**KIRKLEES METROPOLITAN COUNCIL  
INVESTMENT & REGENERATION SERVICE**

**DELEGATED DECISION TO DETERMINE PLANNING APPLICATIONS**

Reference No:	<b>2025/62/92279/E</b>
Site Address:	210, Whitehall Road East, Birkenshaw, BD11 2LL
Description:	Demolition of existing dwelling and erection of detached dwelling
Recommending Officer:	Elenya Jackson

**DECISION – REFUSED**

drawing PROPOSED PLANS AND ELEVATIONS

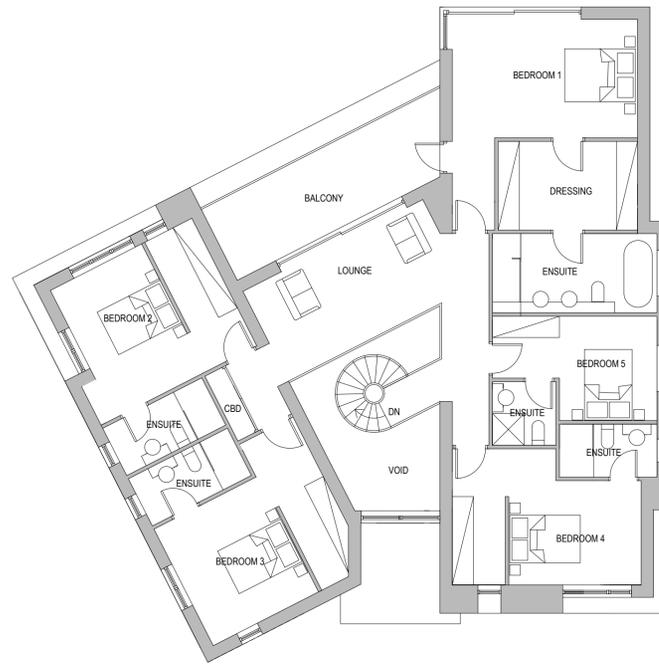
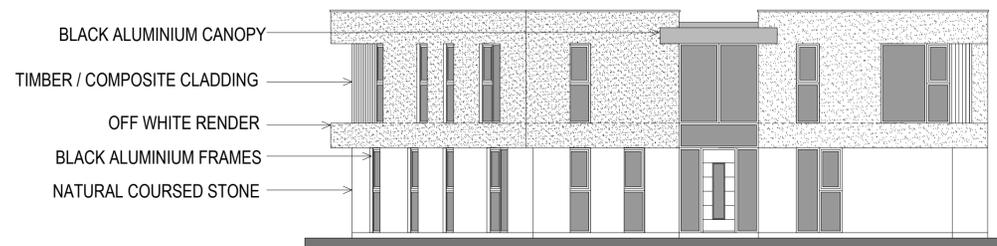
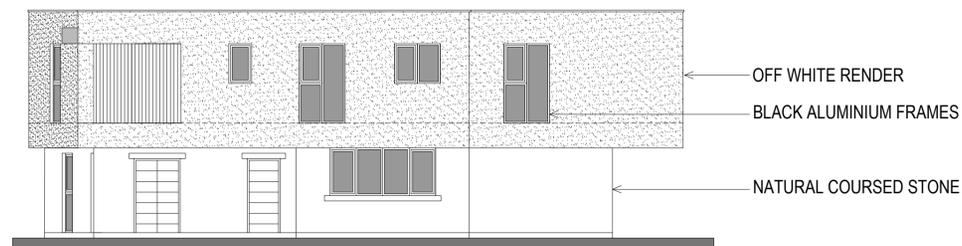
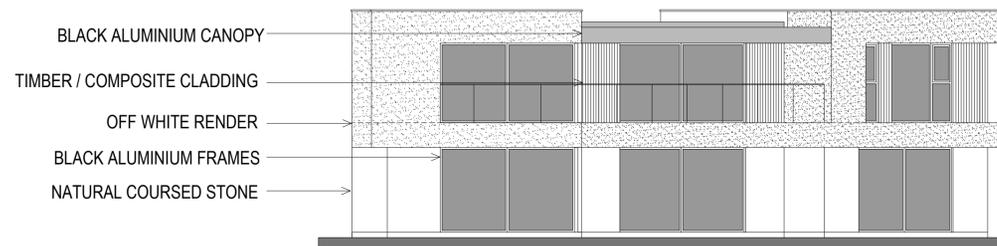
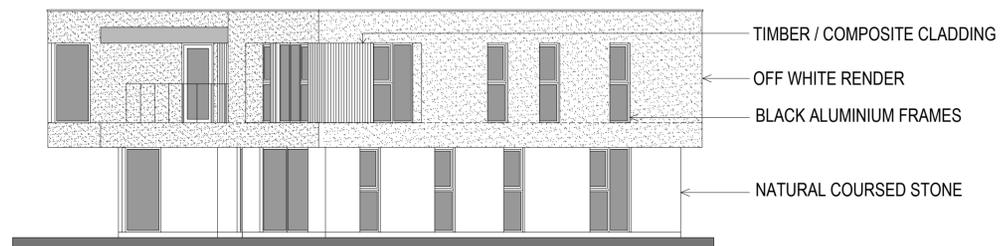
The proposed dwelling would have a depth of 17.4m and a width of 13.2 at its widest point with a maximum height of 6.4m.

The dwelling is proposed to be contemporary in design, running parallel with Whitehall road east along the northern boundary with a splayed south-western elevation. The main components of the shape of the building are two rectangles with an irregular quadrilateral centrally joining the northern and southern sections.

The proposed dwelling features a flat roof, large amounts of full-length glazing, a rendered first floor which would overhang the ground floor of the proposal.

Officers have calculated the approximate volume of the revised dwelling to be 1,177m<sup>2</sup>.

It is considered that due to the scale and mass of the development when considered with its associated hard standing would fail to accord with exemption D of paragraph 154 as it would be materially larger both in volume and scale compared to the existing dwelling on site.

No substantial design justification has been provided to support scheme; however, the proposal would be two storey featuring a flat roof with a rendered first floor and large amounts of glazing. It is considered that the proposed dwelling would have a prominent position in the street scene and would appear top heavy and poorly integrated into the landscape.

No street scene plan has been submitted to support the application. However, it is considered that with the layout whereby the proposed garage would back onto Whitehall Road East and be positioned closer to the boundary than both the existing development and the proposed dwelling, it would appear out of keeping with the revised building line, relate poorly to the street scene, and fail to make a positive contribution to the character of the area. This would conflict with Principle 8 of the Housebuilders Design Guide.

While contemporary design can be appropriate in certain contexts, the plot is not sufficiently separated from neighbouring properties to be read as an isolated dwelling within the public realm. Therefore, architectural cues from surrounding buildings would be more appropriate to ensure a coherent contribution to the street scene. The proposed dwelling makes limited reference to the local vernacular, and as a result, fails to comply with Principles 2, 14, and 15 of the Housebuilders Design Guide, as well as Policy LP24(A) of the Kirklees Local Plan.

Furthermore the countryside setting of the development is such that the proposal would represent a stark and highly urbanised design that is not in keeping with the established local character of the street / existing site. Due to its scale, design, location, and prominence, the proposed development would appear incongruous within its rural setting. The contemporary form, lacking reference to the local vernacular, would fail to integrate with the character of the area or contribute positively to the street scene. Consequently, the proposal conflicts with Principles 2, 8, 14, and 15 of the Housebuilders Design Guide and Policy LP24(A) of the Kirklees Local Plan and policies within chapter 12 of the NPPF.
